CITY OF ALBUQUERQUE

March 4, 2024

Re: Costco Wholesale Fuel Expansion
1420 Renaissance Blvd NE
Preliminary Site Plan for DFT Approval
Plan Date 8-31-23 (F16D005G)

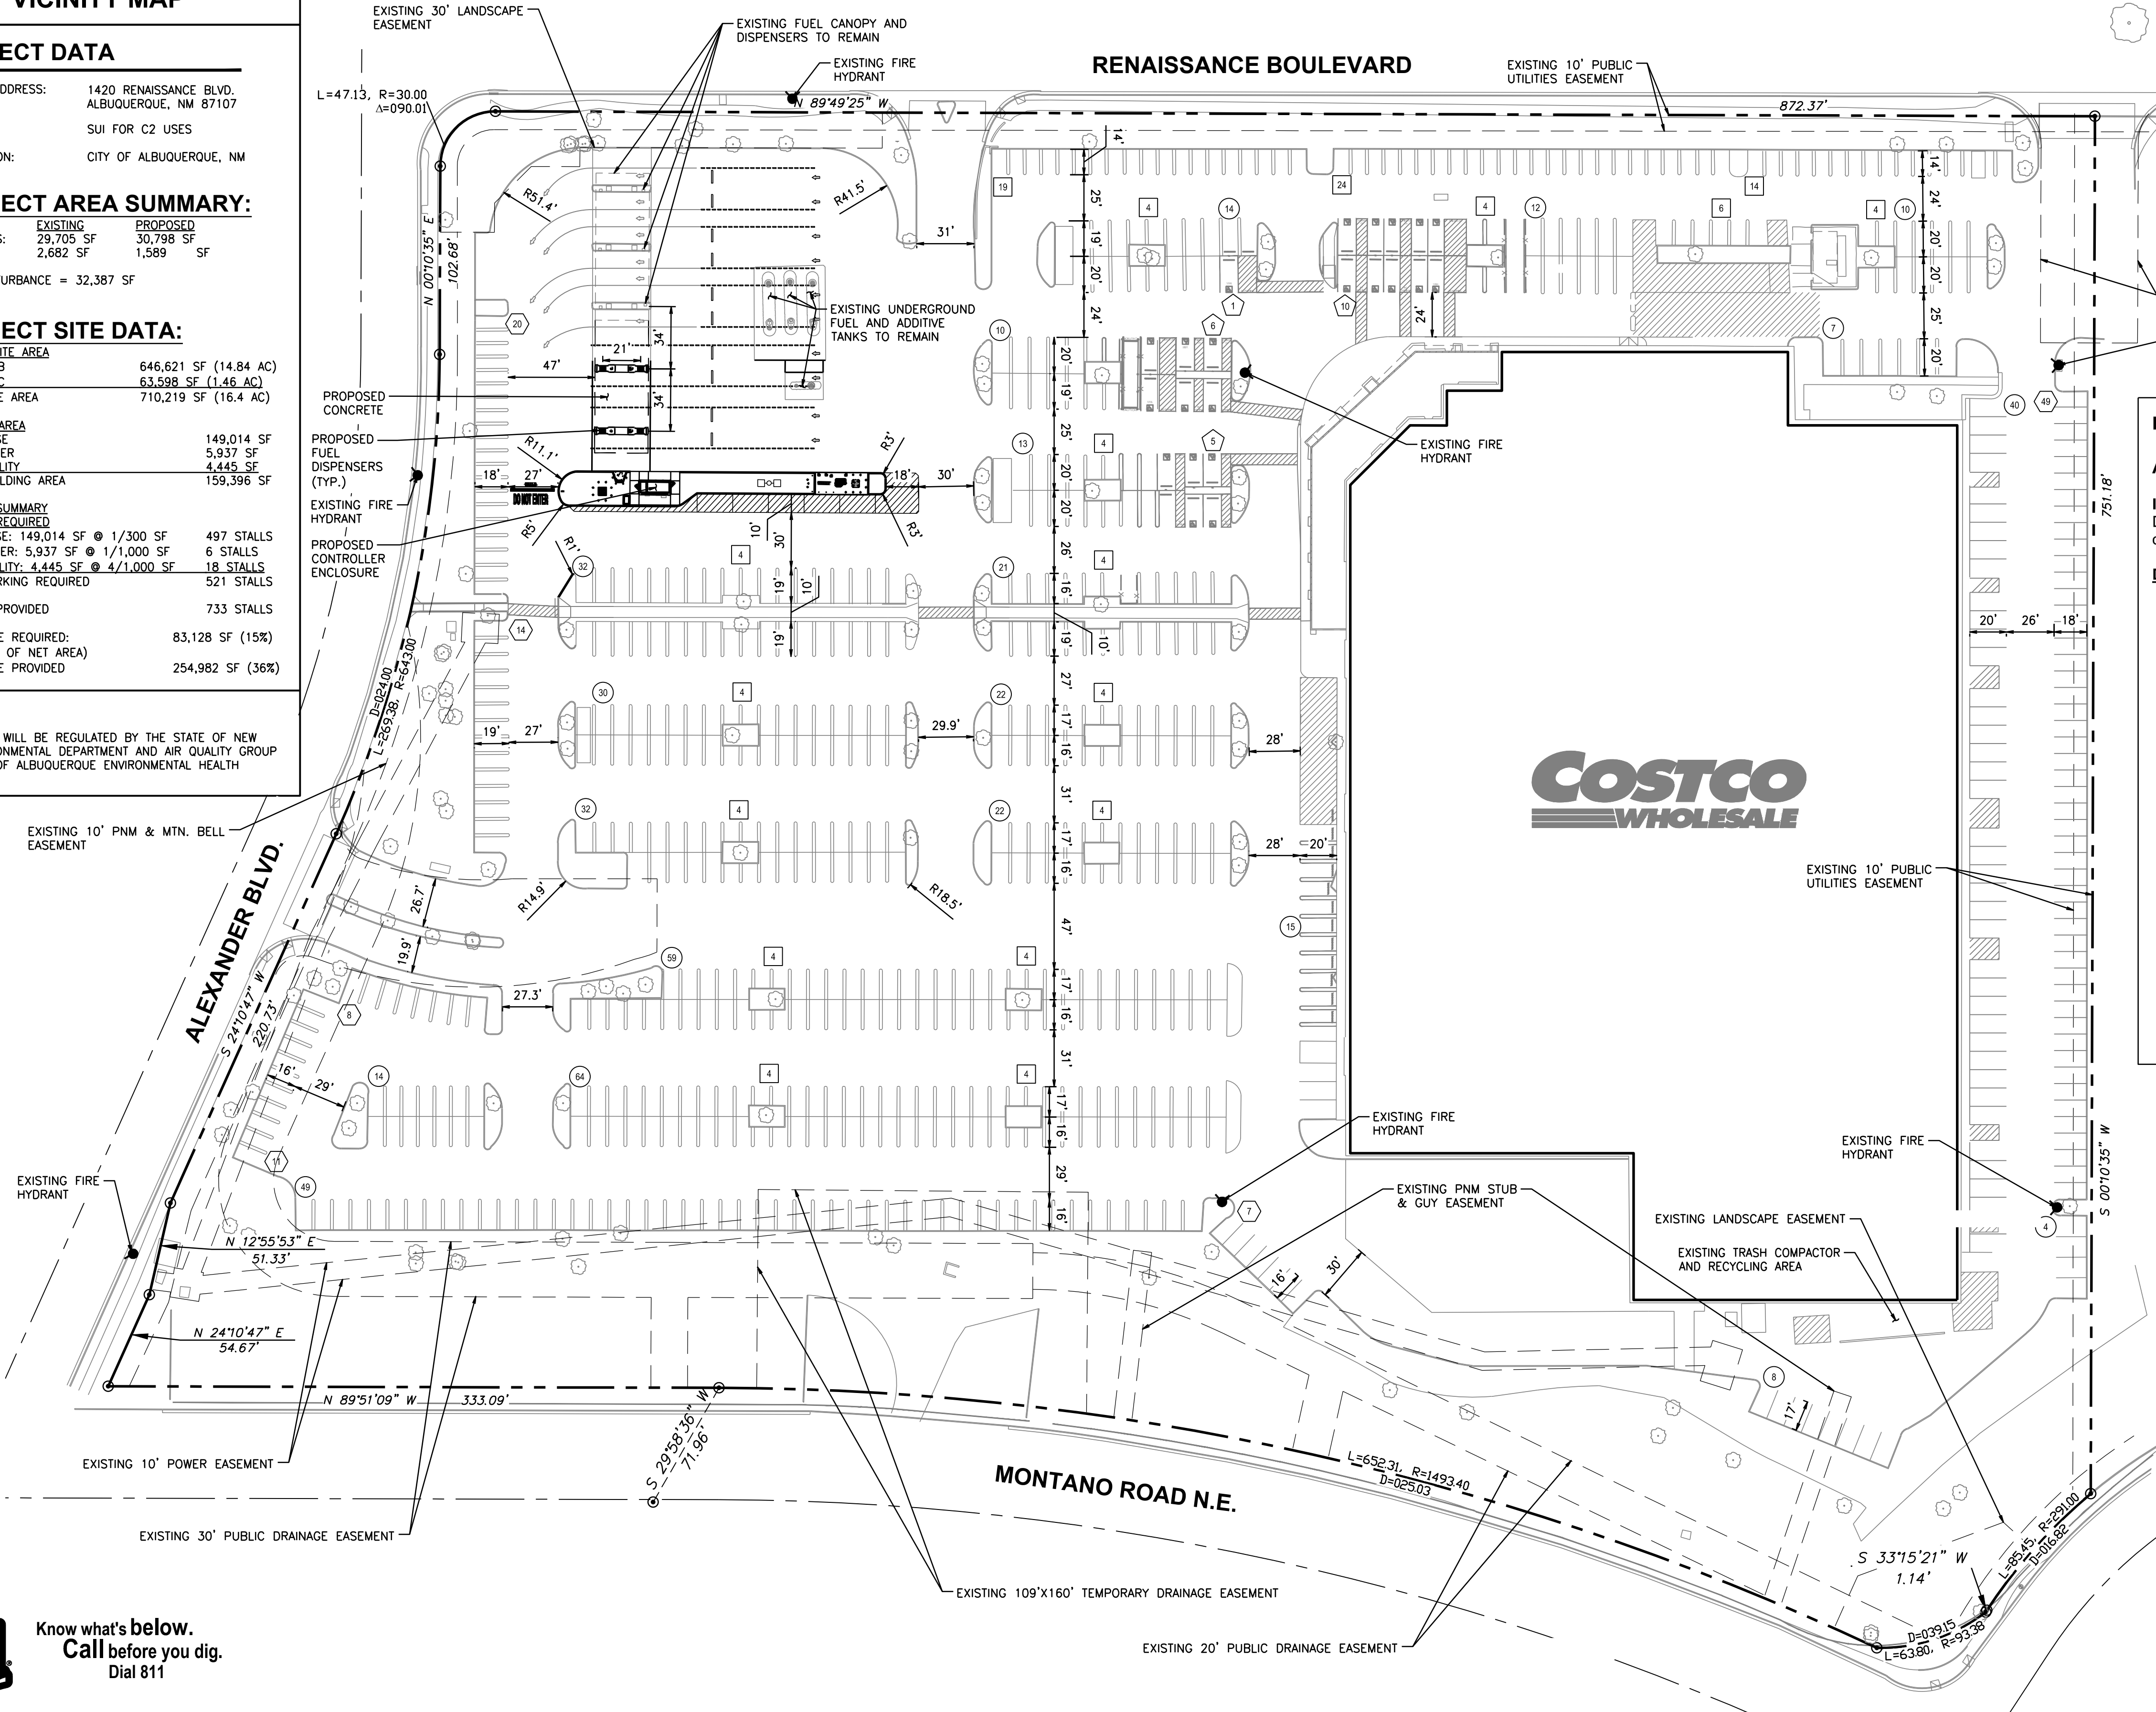
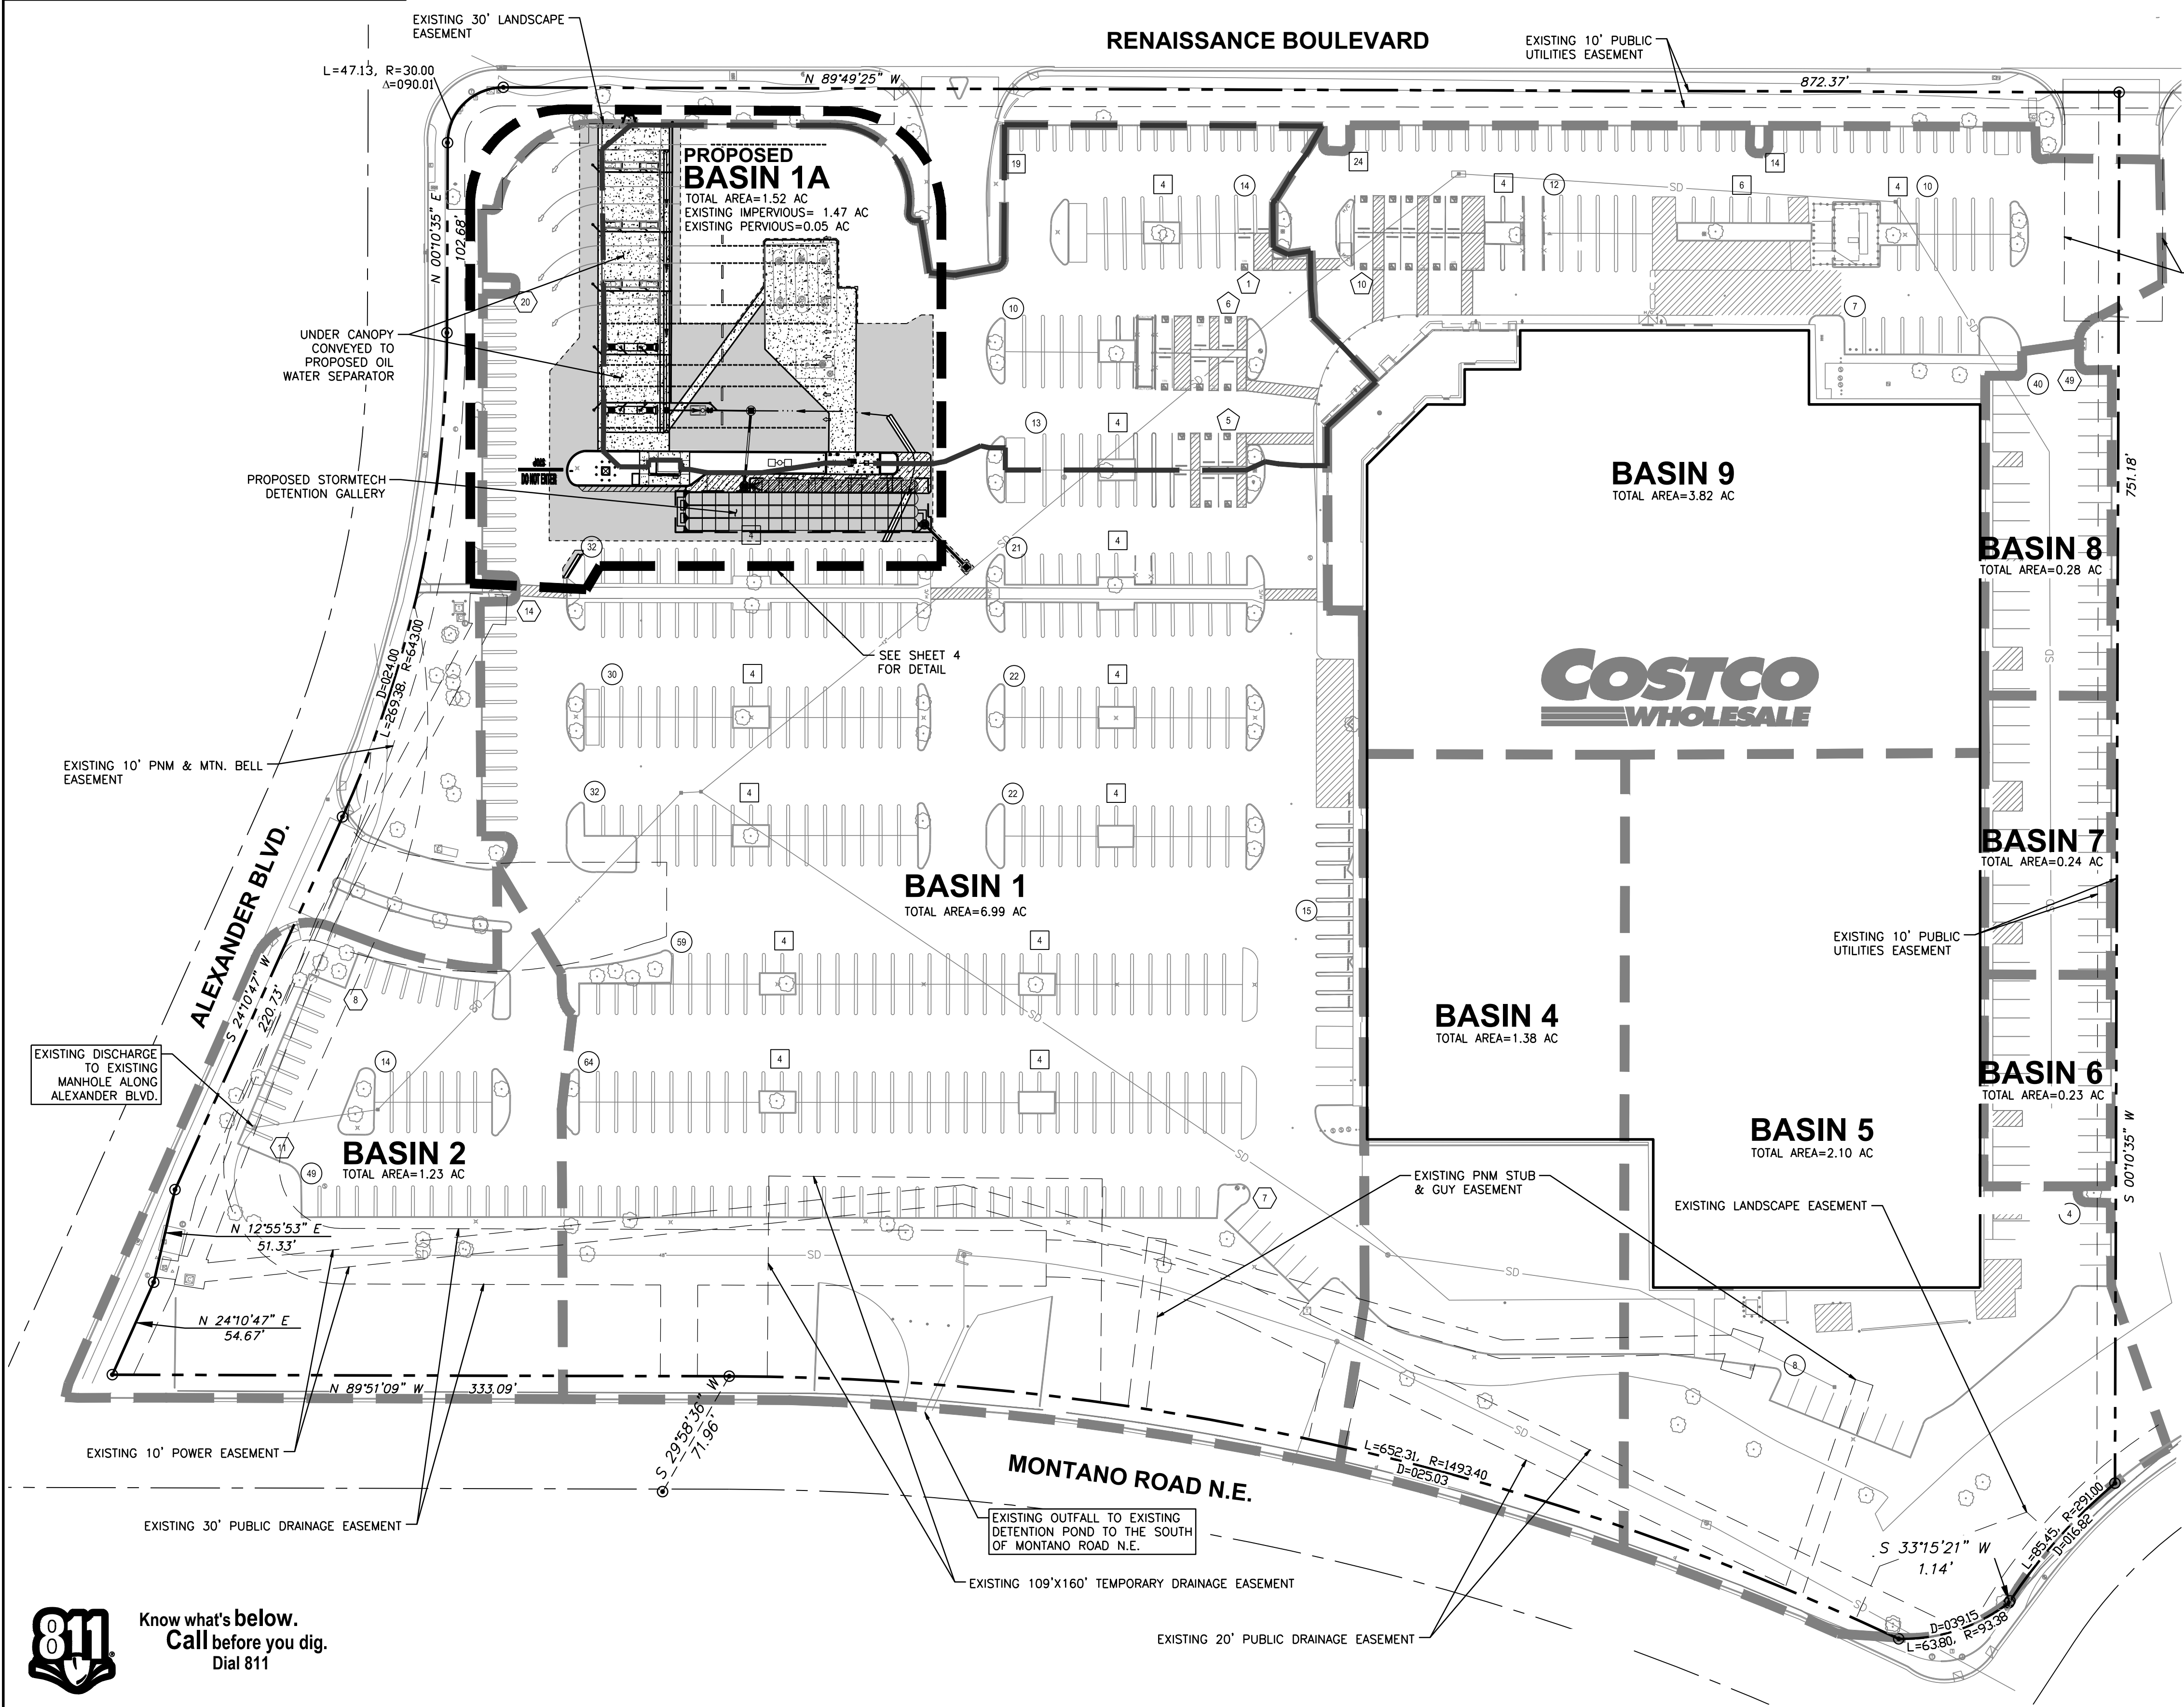
- (1) One of the existing parking islands is proposed to be modified where radii are being removed and reduced to only 1 foot. Per the DPM, the radii are to be 15 ft and 2 ft.
- (2) All one-way drives shall have "One Way" and "Do Not Enter" signage and pavement markings. Please show detail and location of posted signs and striping.
